Jeanie Bourke - Re: 90 Vesper St., BP#2015-00977 plan review comments

Jeanie Bourke
CEO/LPI/Plan Reviewer

Plot Plan.

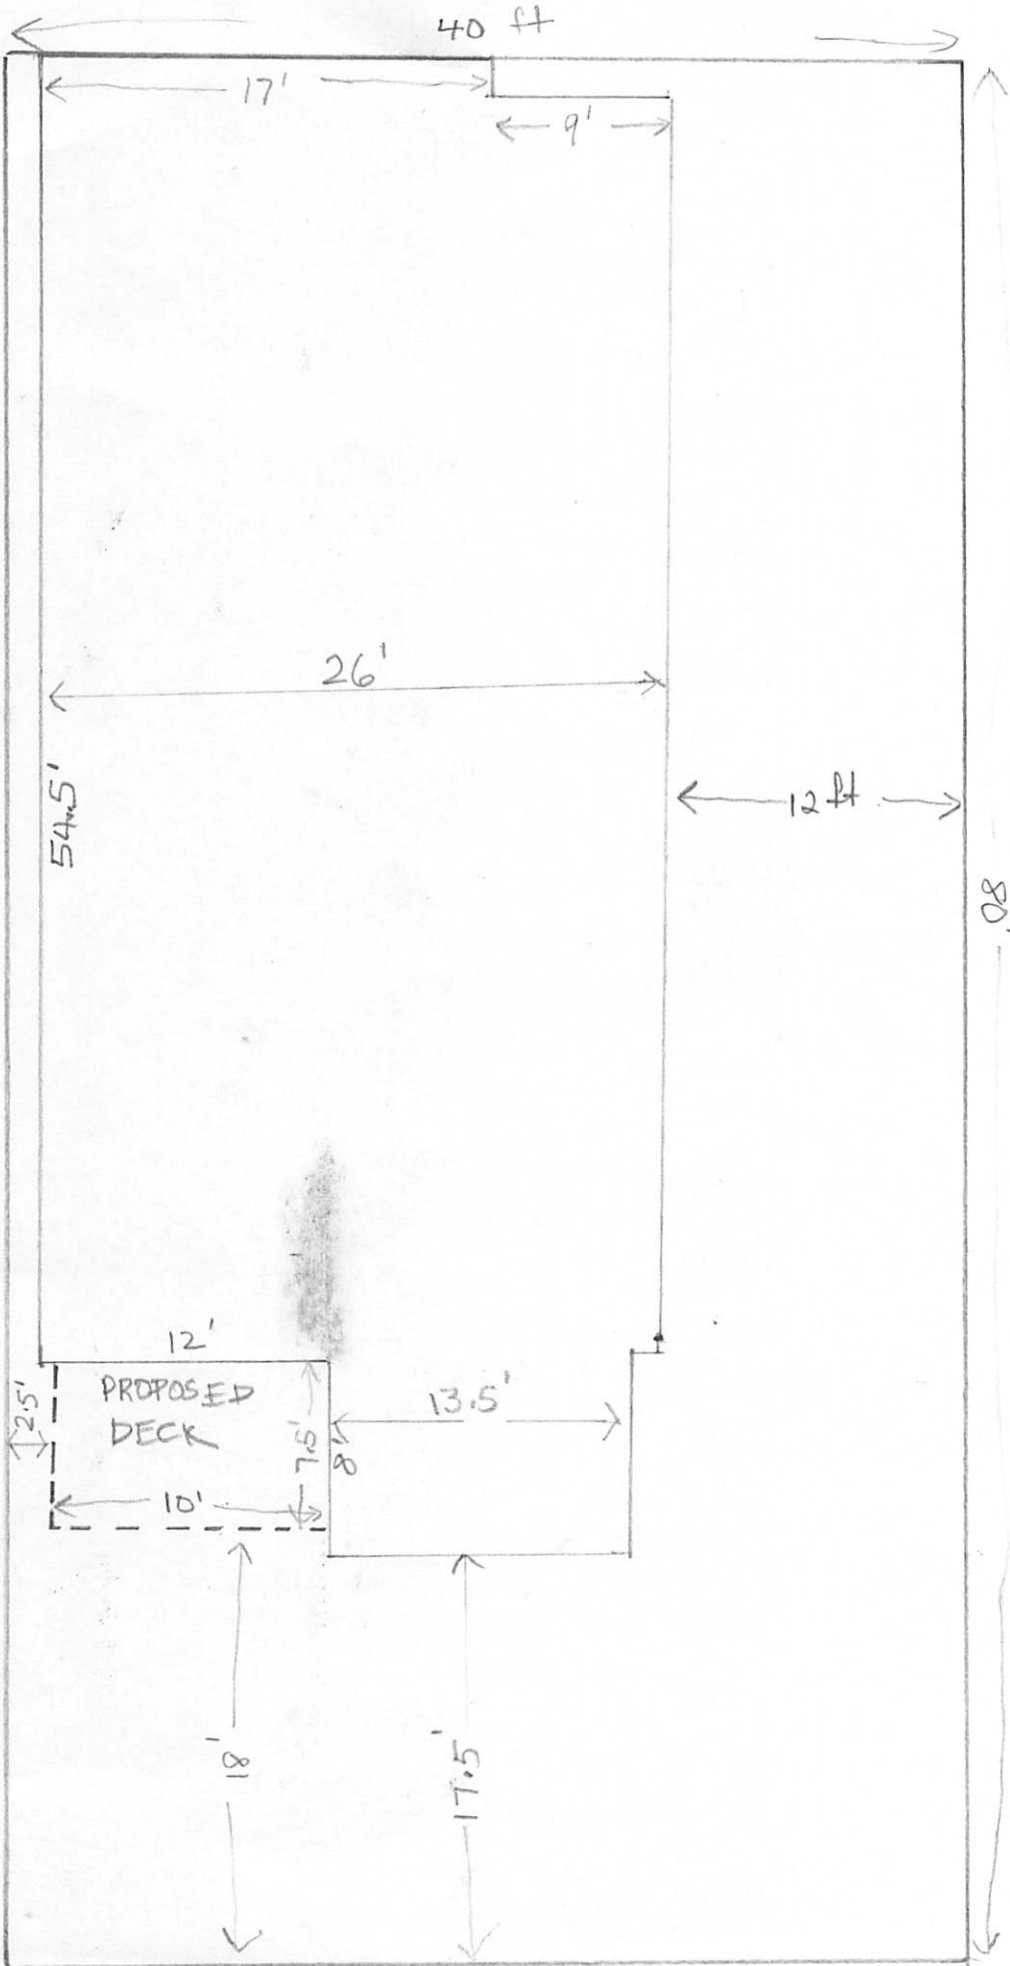
If you want to be less than 5' from the PL you will need to get the easement. I just wanted to make sure you understood your options.

On the other side, you need to provide the distance to the farthest most building projection. Is there a bumpout on the left side? The Assessors sketch shows this.

As I informed you previously, the new R-6 Zone has been adopted. This now allows a 10' rear setback, which this deck meets. The big change is the side setbacks. A structure can now have as low as a 0' setback to the PL if the cumulative side yard setbacks are a minimum of 10'. Your plot plan shows 12' on the left side, is that accurate? There is a caveat for a deeded maintenance easement on the lesser side. The easement can be incorporated into the chosen setback distance. See this code language:

Once you decide what to do, please change all the plans to reflect this, ie. the plot plan, deck dimensions, etc. so that I am reviewing the accurate information. Previously, I had only done the zoning review. I have looked at the building construction details and have several comments that need to be addressed. See the attached plans with markups. All revised plans shall maintain the exact pdf file name as this will automatically replace the originals.
